From: [REDACTED]
Sent: 09 April 2014 16:40
To: 'Nigel Locke'
Subject: RE: 1 Normans Drive, Bognor Regis (FP/66/13)

Whilst I agree that the changes would be capable of complying with our new policy on the amount of external amenity space, I do not consider that the changes are capable of overcoming the first reason for refusal on character. Furthermore, the changes do not alter the fact that the rear garden for the new dwelling is in full view of the rear first floor windows on no. 1 and that there will be overlooking between these windows and the private garden and vice versa and at a distance of less than 10m. This suggests to me that this site is unsuitable for a new dwelling due to the size of the available plot and this adds to the arguments over the character of the area.

SOUTH WEST [front] 1/100

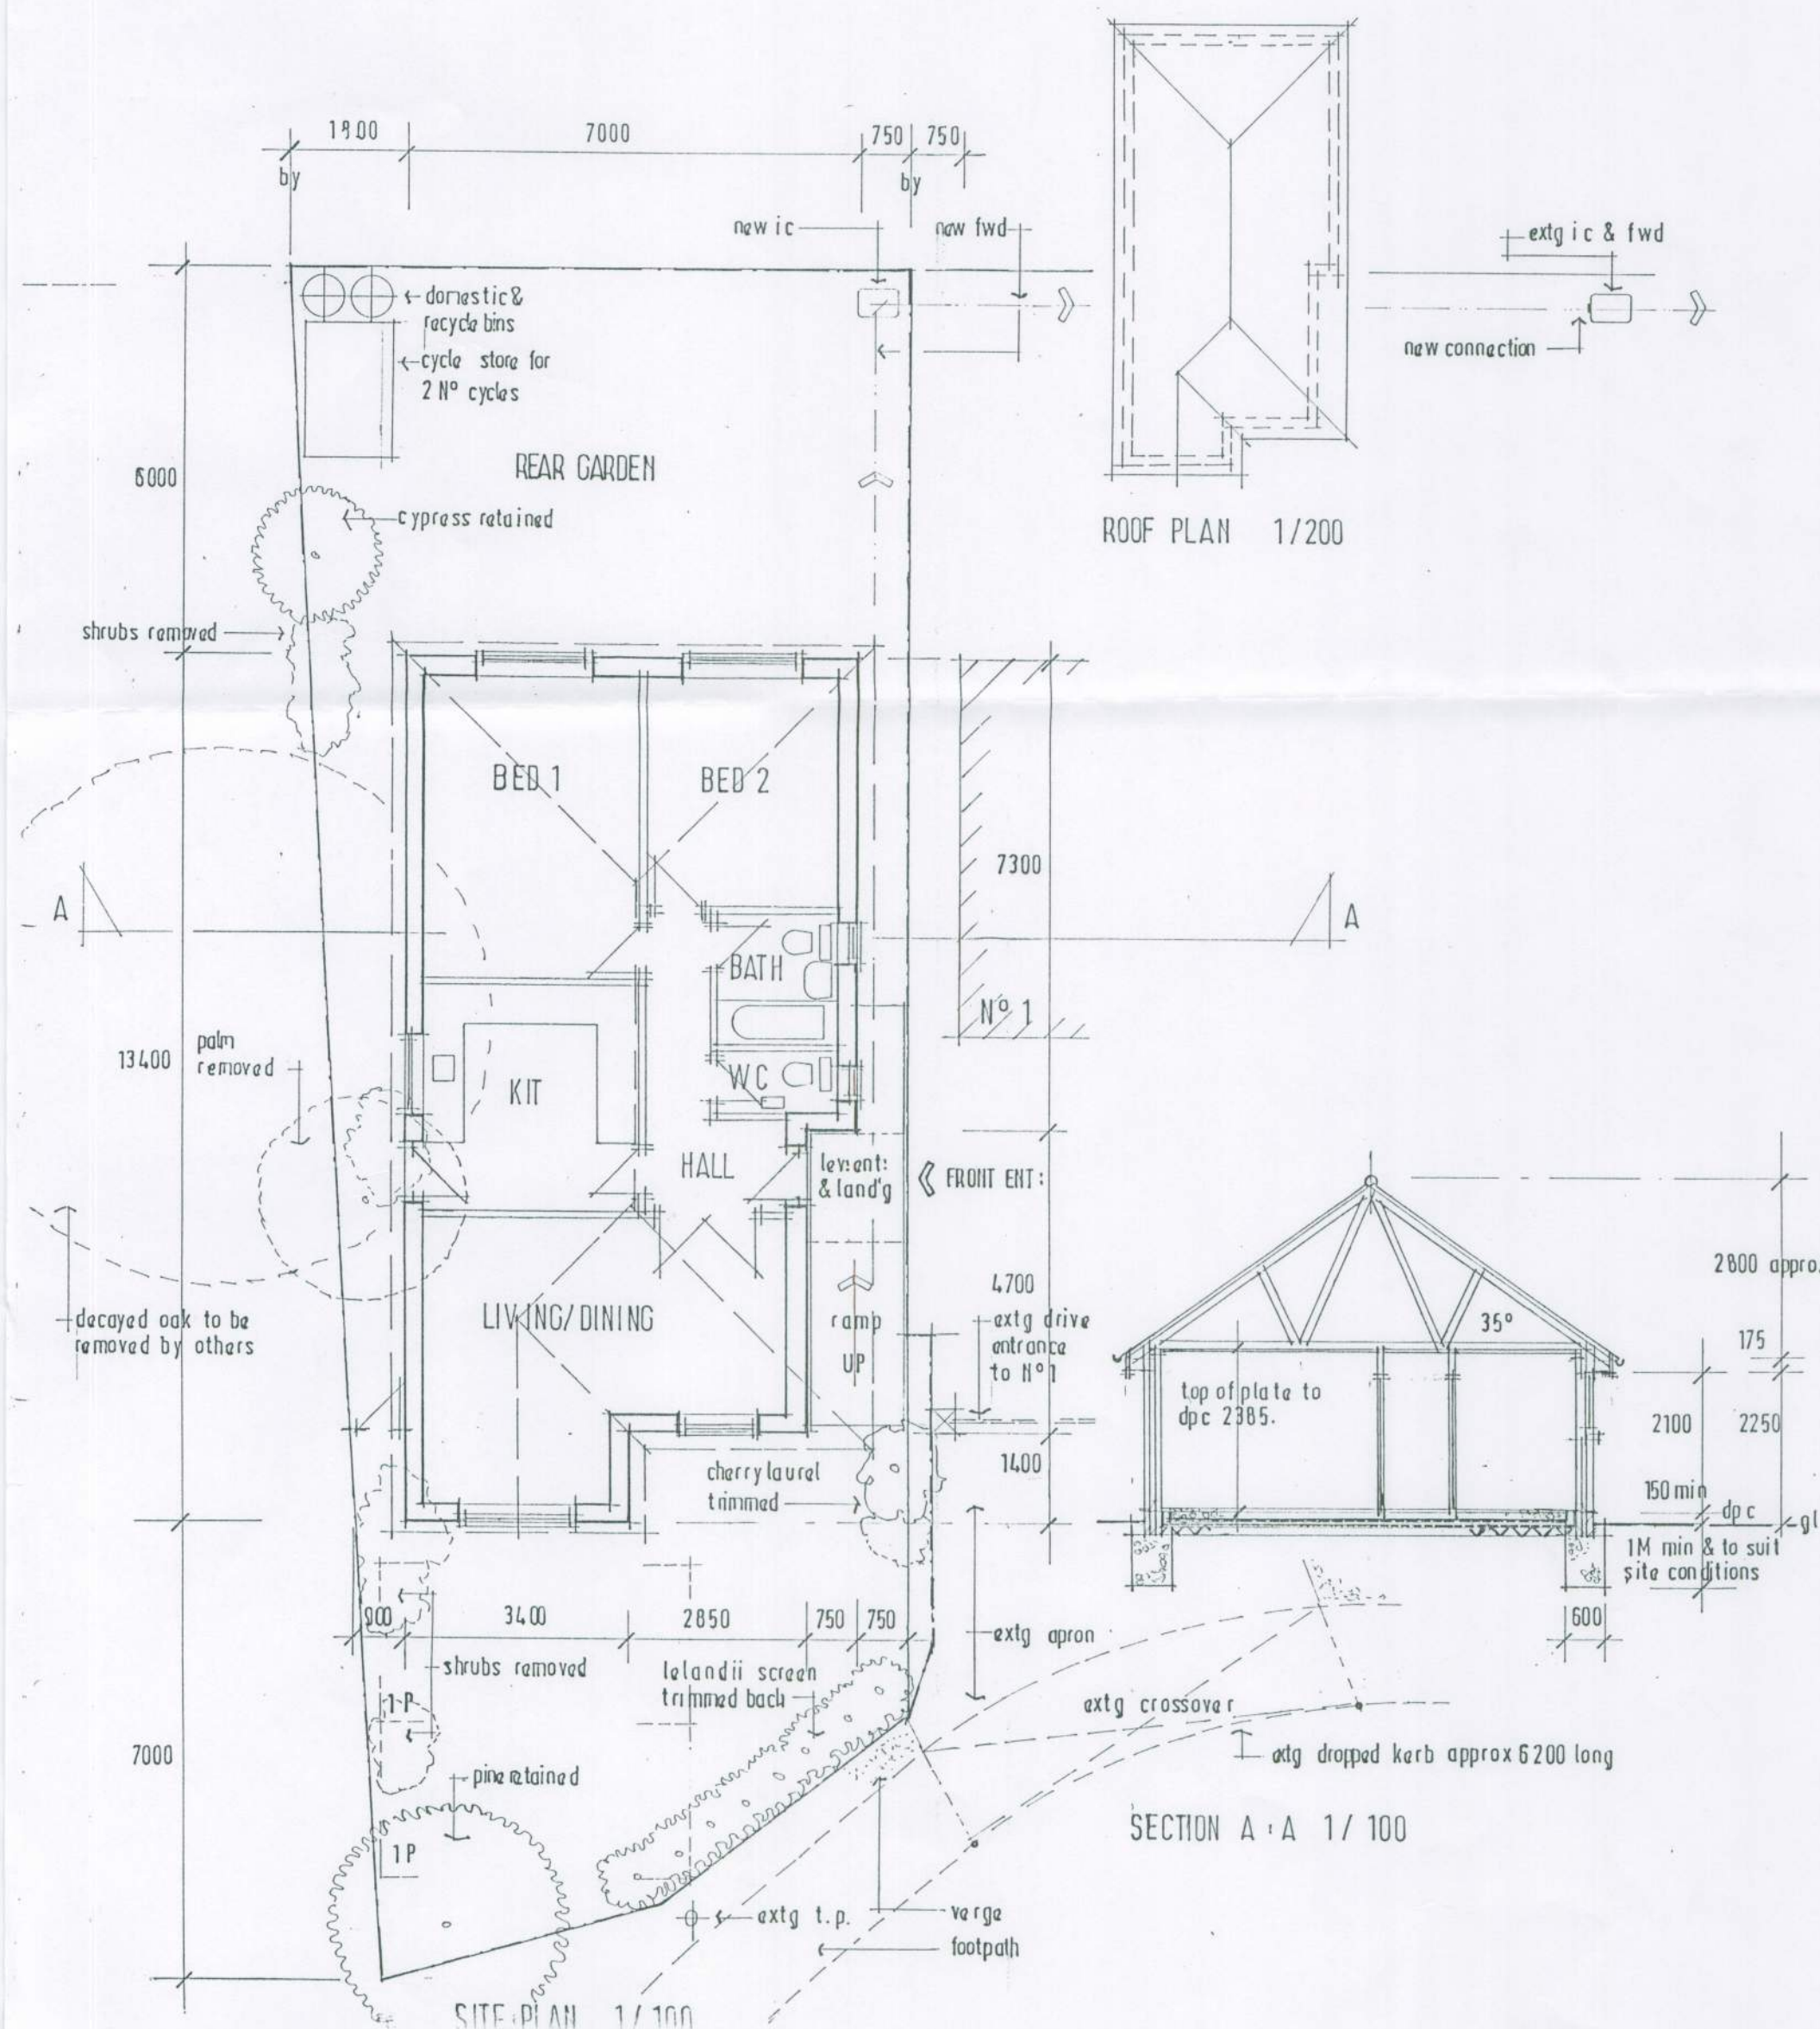
I also have concerns over how private the front garden will be given that it is open to the road. Presumably, landscaping would be proposed to increase the privacy of this area. Finally, you should also have regard to our emerging policy on internal space standards (D DM2). The application submission was deemed to meet the standards but with a smaller footprint, this may no longer be the case.

I attach a revised design for a two bedroom chalet bungalow. The window on the north first floor elevation will be obscure glazing as it only serves a bathroom, so the only window with an outlook on the first floor will be the front south facing window that overlooks the front garden and roadway. The proposed rear garden to the new dwelling will now have a depth of 10 metres and an area of about 95 square metres, to conform to the Council's current outside space standards for a detached two bedroom dwelling.
